**Consultation Response from Mike Hibbert,
 KC Waste Strategy(Refuse & Recycling)**

2022/93397 Highfields Centre, New North Road, Huddersfield, HD1 5LS

Date Responded: 27/02/2023.

Responding Ref: WPS 23-008

**Proposals:**  
**Building A**  
 Recommended capacity is 8 wheeled bins, due to the other constraints as mentioned above, this cannot be accommodated within the boundary of the site, whereas a storage area containing 6 bins can be accommodated. This is considered to be a reasonable compromise.

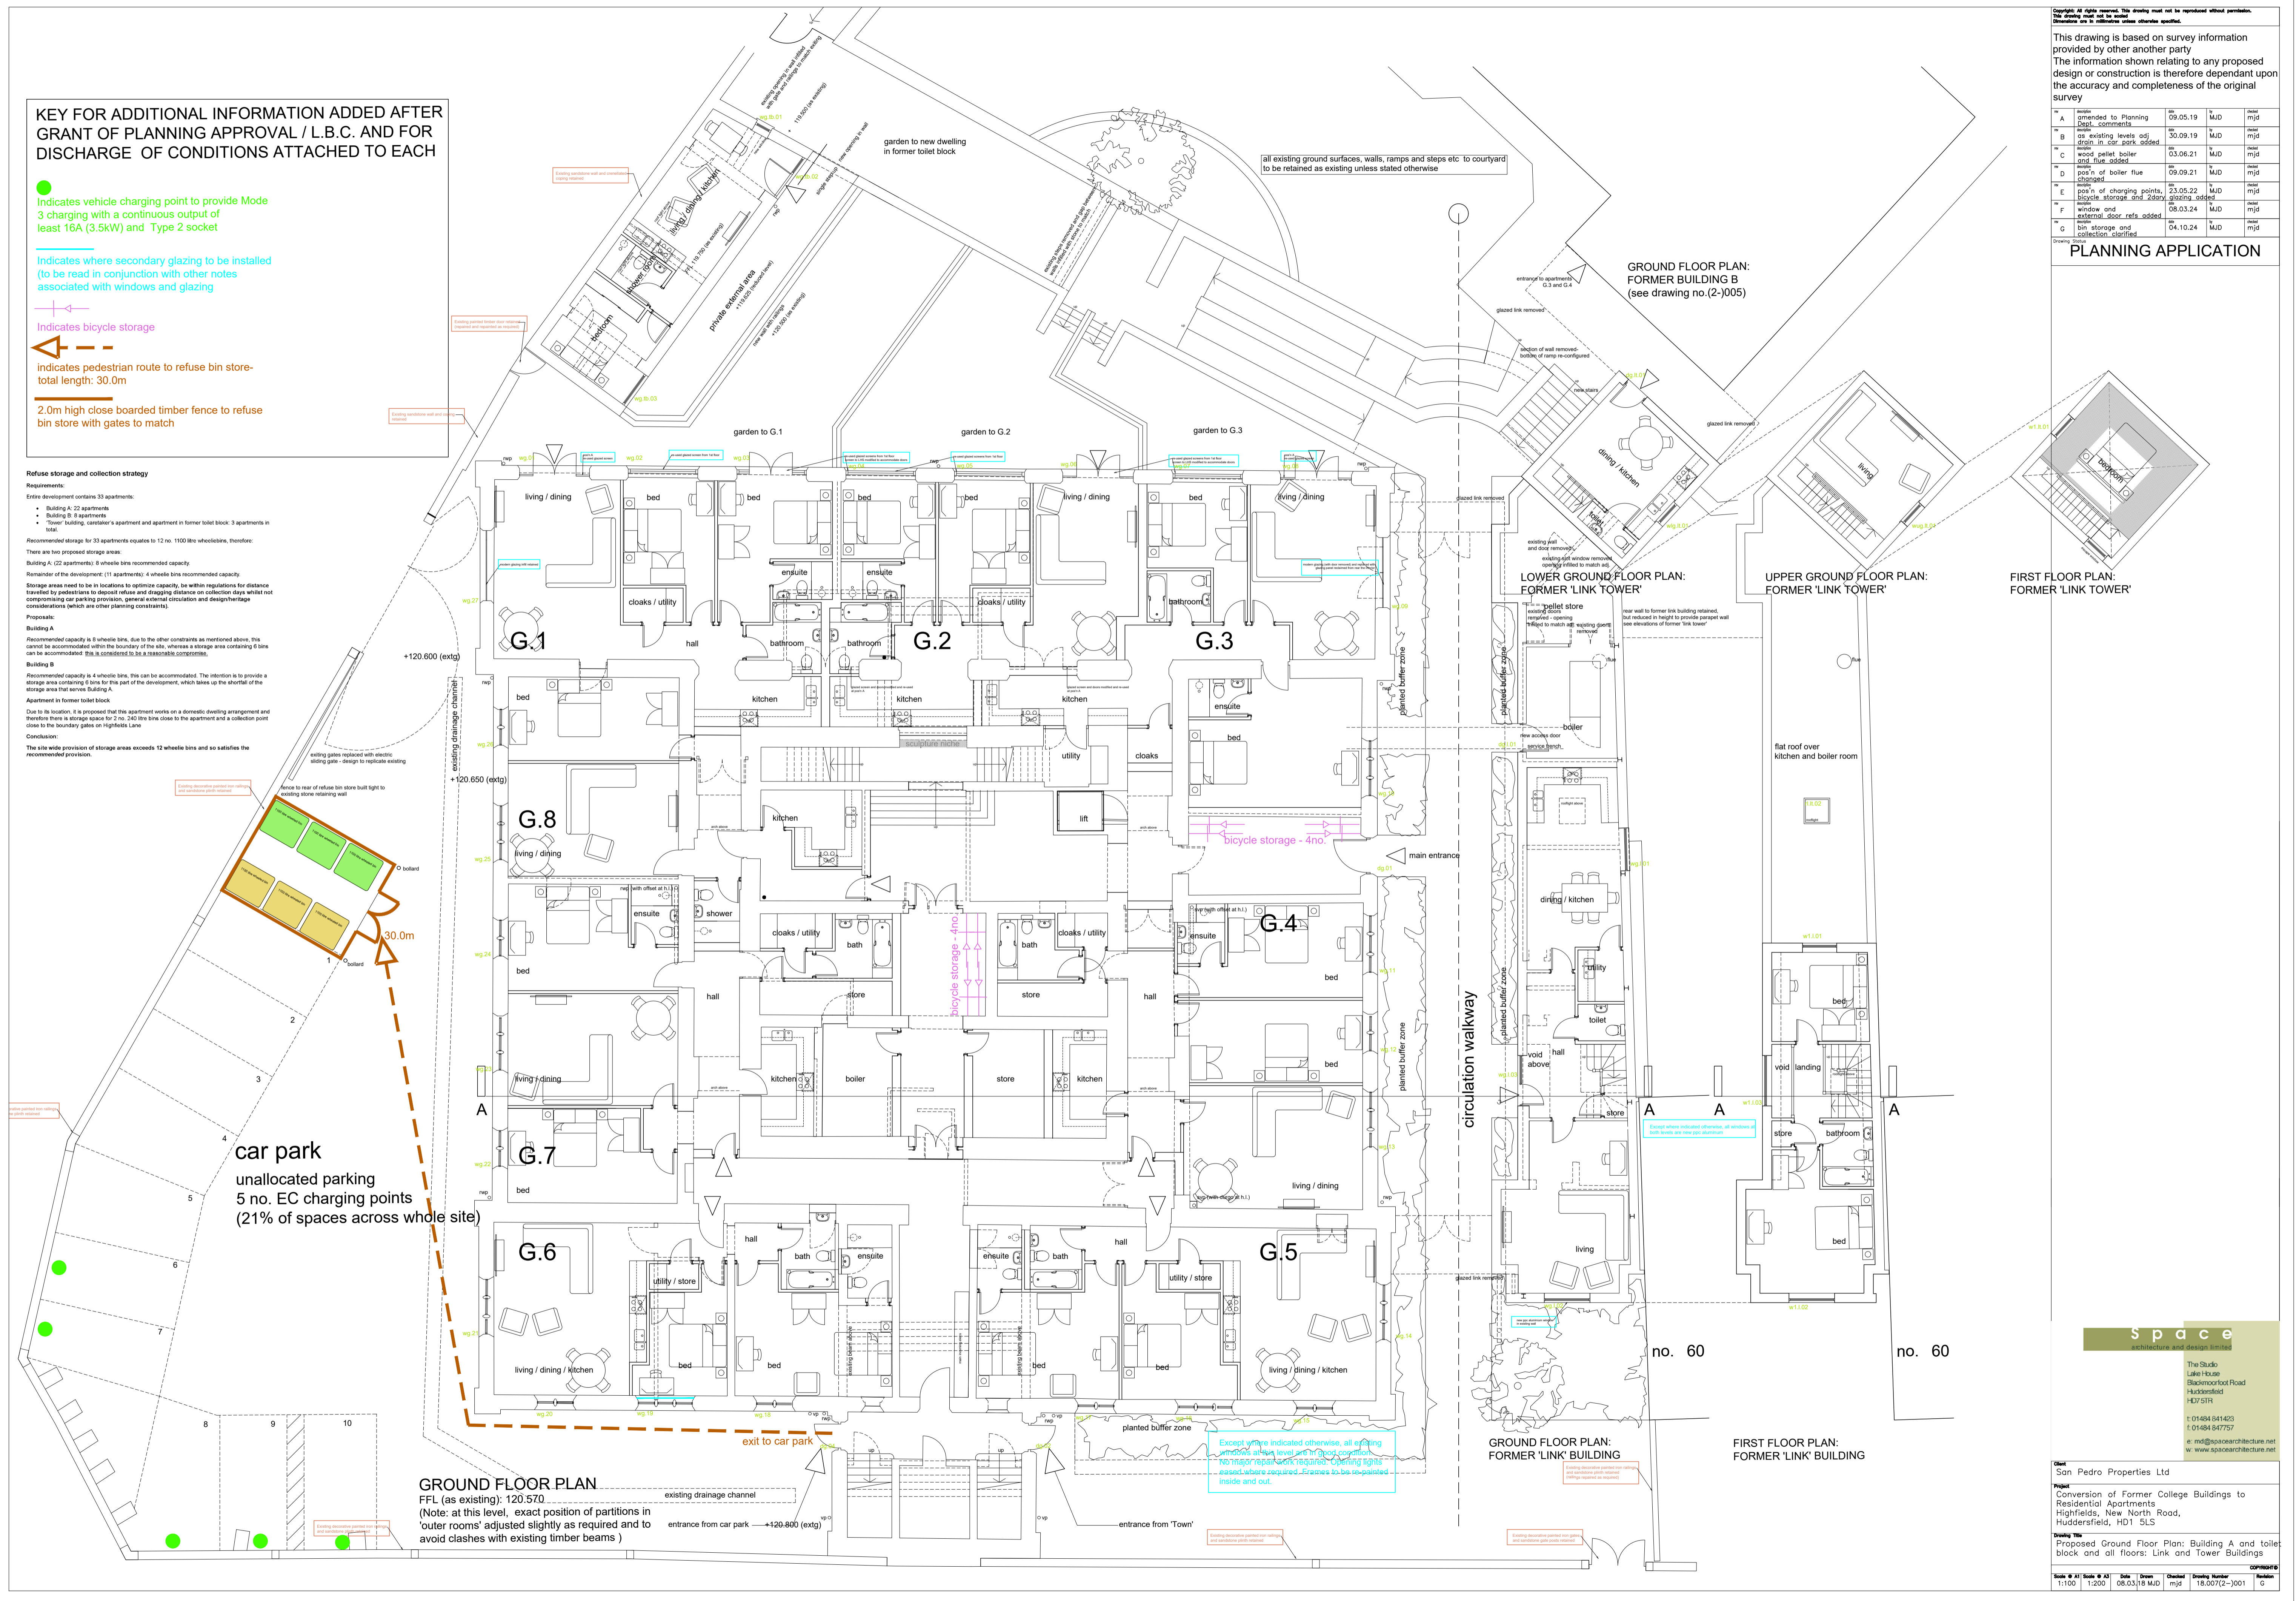
The development is for the conversion of the vacant former college building to 33 apartments. The applicant has submitted drawing ref 18.007 (2-) 001 Rev E dated 23/5/22 that shows the location of a bin store on the northern side of the main building A containing 6x1100ltrs wheeliebins with access to Highfield Road through sliding security gates. The Landscape drawing ref SPP/H/541/1a Rev A dated 2 Jun 19 shows a bin store at the eastern end of the carpark for Block B accessed from Highfield Road/ Newhouse place junction.

- For 33 apartments the recommended waste storage provision is 5,940 ltrs (180 ltrs x 33) for both residual and recycling bins. Appropriate waste storage provision would be 12 X1100ltrs wheeliebins.
- If sufficient waste storage cannot be accommodated, then there may need to be a review of the configuration of residual and recycling provision/ containers or the

- The plan for Block A shows six wheeliebins with dimensions of approximately 1130mm x 800mm. Guidance indicates the floor space for a 1100ltr wheeliebins is 1575mmx1190mm with space to manoeuvre the bins within the store so the bin store dimensions would depend on configuration within the store. Additional information is required detailing waste storage, containers, capacity, and design of the waste storage compound including, screening (if any), surfacing and security. Appropriate standards are detailed in the Kirklees Waste Management Design Guide 2020. Bin store surfaces should be durable and waterproof enough to withstand heavy duty cleaning such as power washing.

- The main entrance to the Building A is on the south elevation of the block. The walk distance from the entrance of the building to the proposed bin store appears to be excess of the 30m as specified in guidance BS5906:2005.

- No details have been provided in relation to the construction, size and number of bins proposed to be in the Building B bin store.
- Waste storage presents a fire risk and therefore must therefore comply with fire regulations (refer to BS 5906:2005 Waste Management in Buildings; Building Regs 2010 Part H6 and CFP-A-E Guideline No 7:2022 F). Both proposed bin stores are more than 6m from properties.
